**Alexandria Park Community School Redevelopment,
Park Road, Alexandria (SSD 8373)
Notice of Exhibition**

TfNSW has reviewed the exhibited Environmental Impact Statement (EIS) supporting the proposed development and provide the following comments.

TAB A – Detailed Comments on State Significant Development Application

1 GROUND FLOOR - CAMPUS PLAN
1 : 500

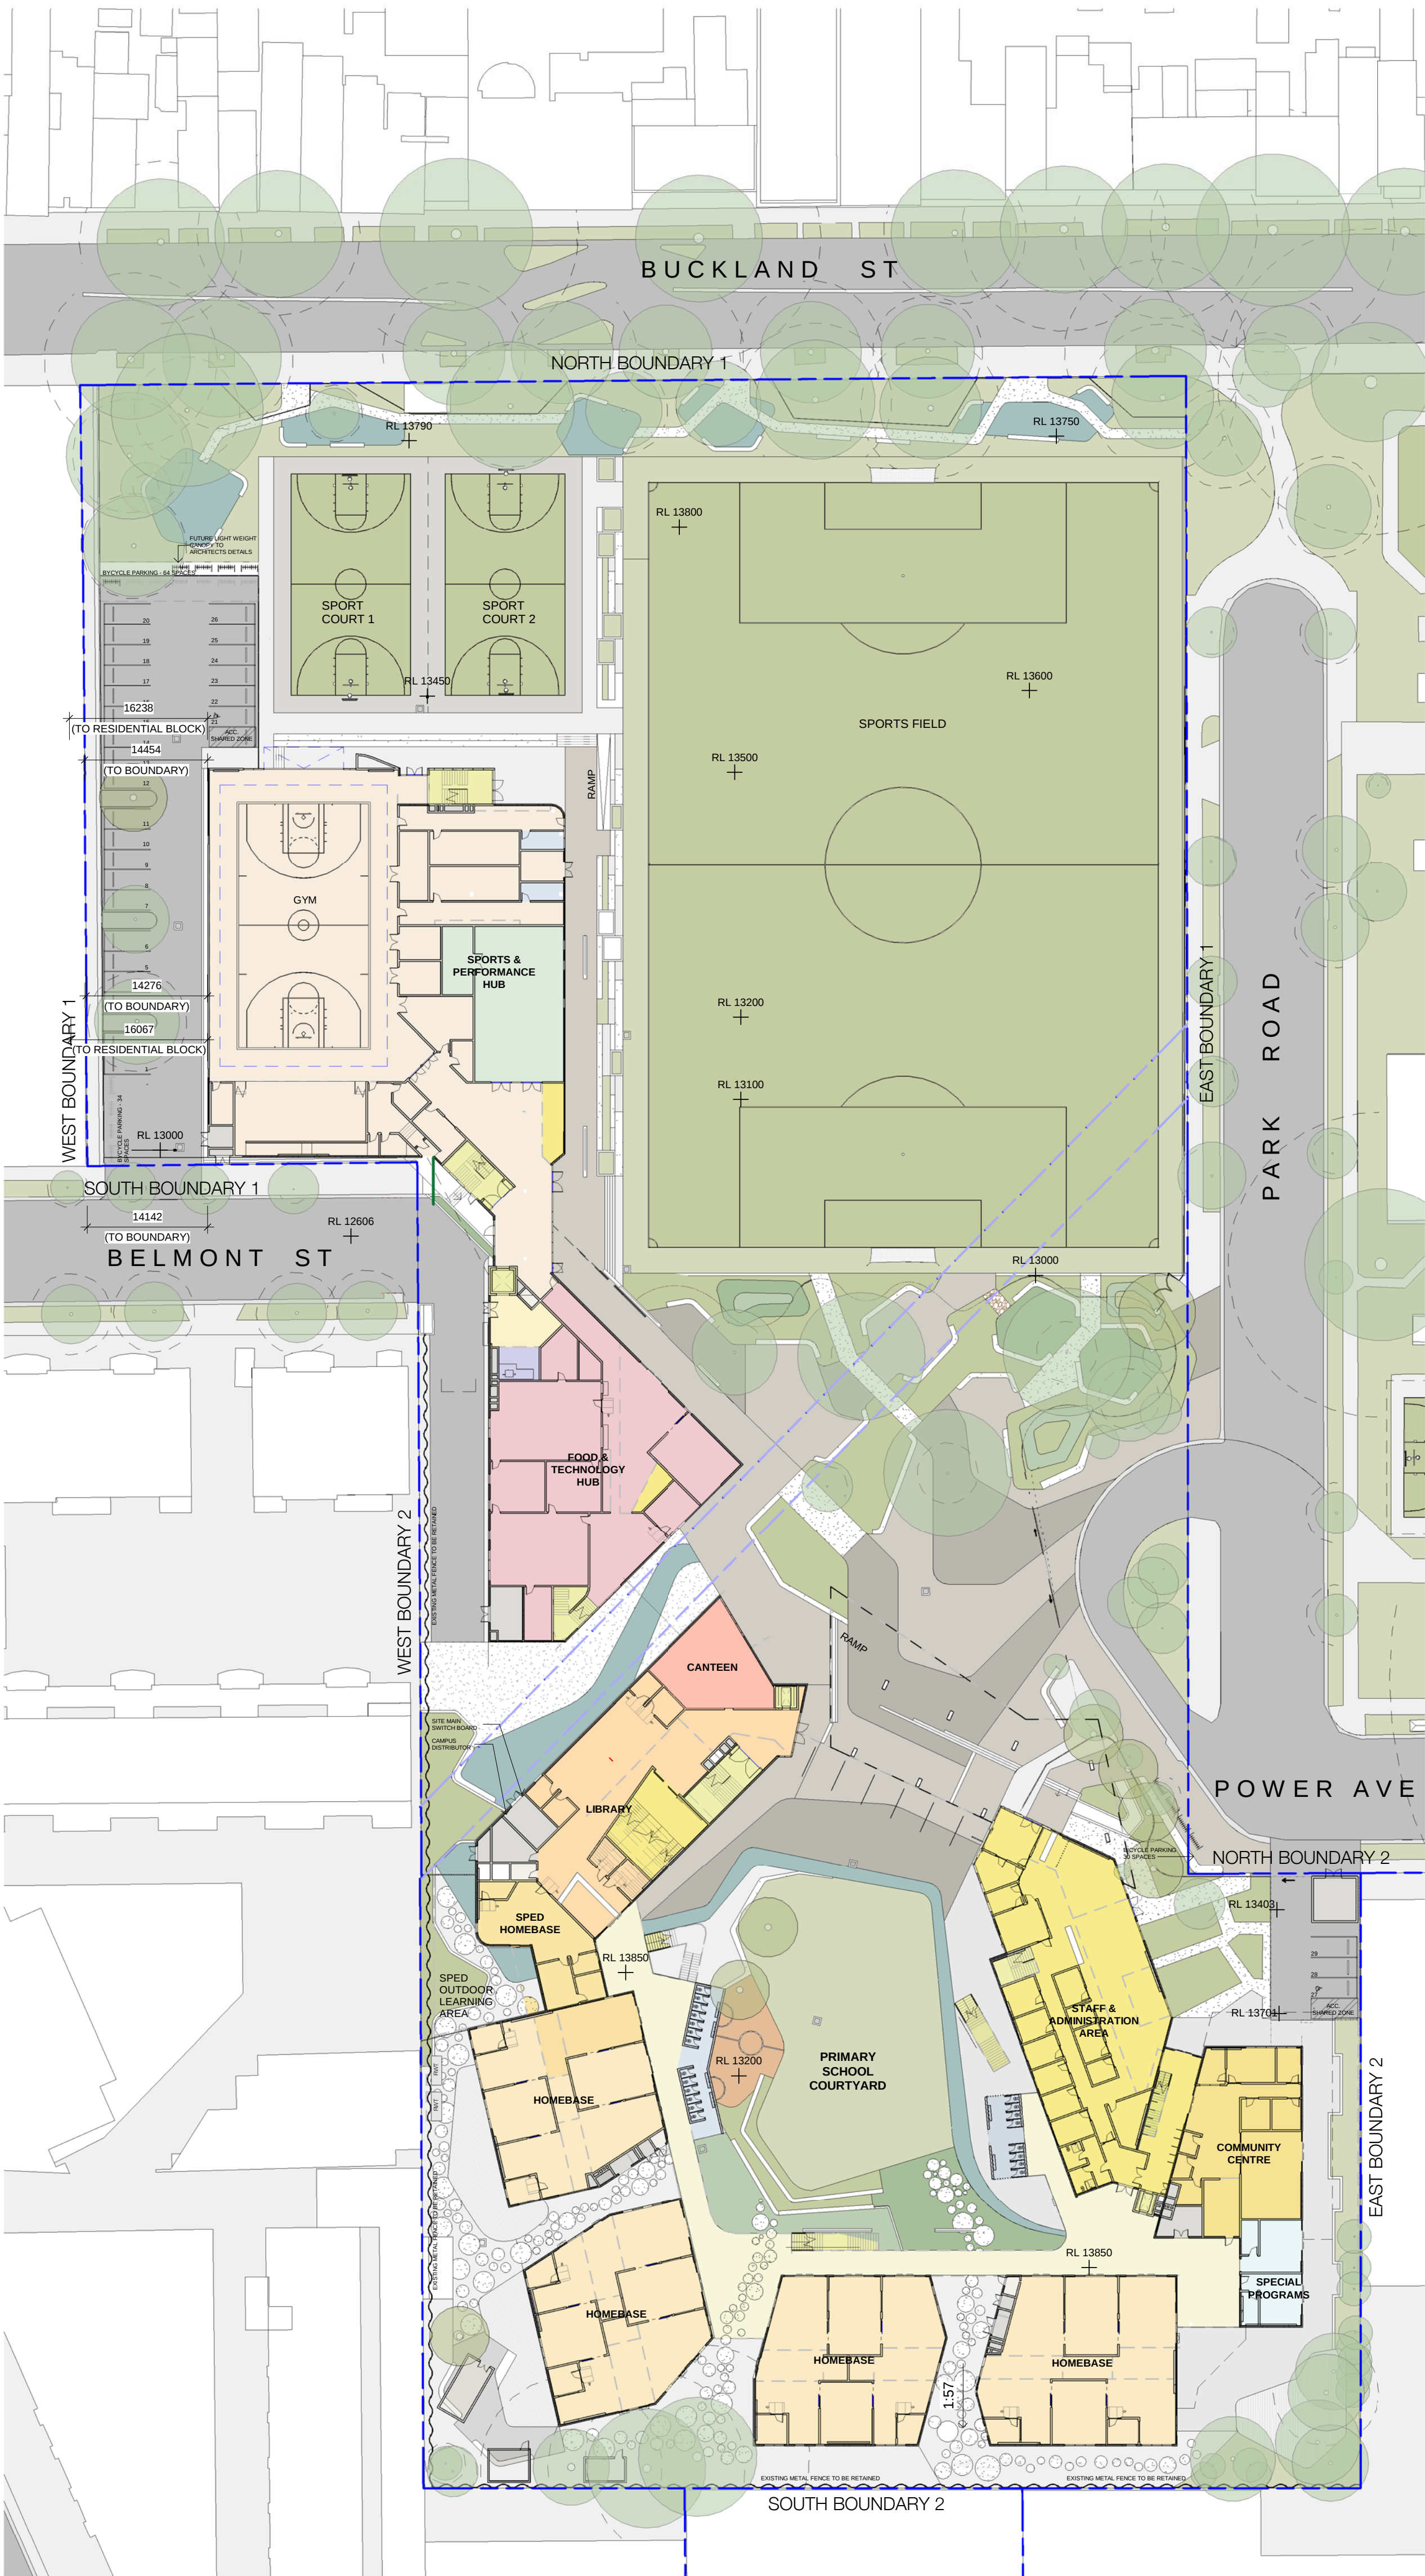
The proposed location of bicycle parking spaces within the staff parking areas would compromise student safety as vehicle movements within the car park could conflict with bicycle movements. Furthermore, Clause 2.5.1 of AS 2890.3: *Parking Facilities for Bicycle Parking* recommends that bicycle parking be located clear of driveway entrances/exits.

That bicycle parking should be provided near all site access points and separated from vehicle movements.
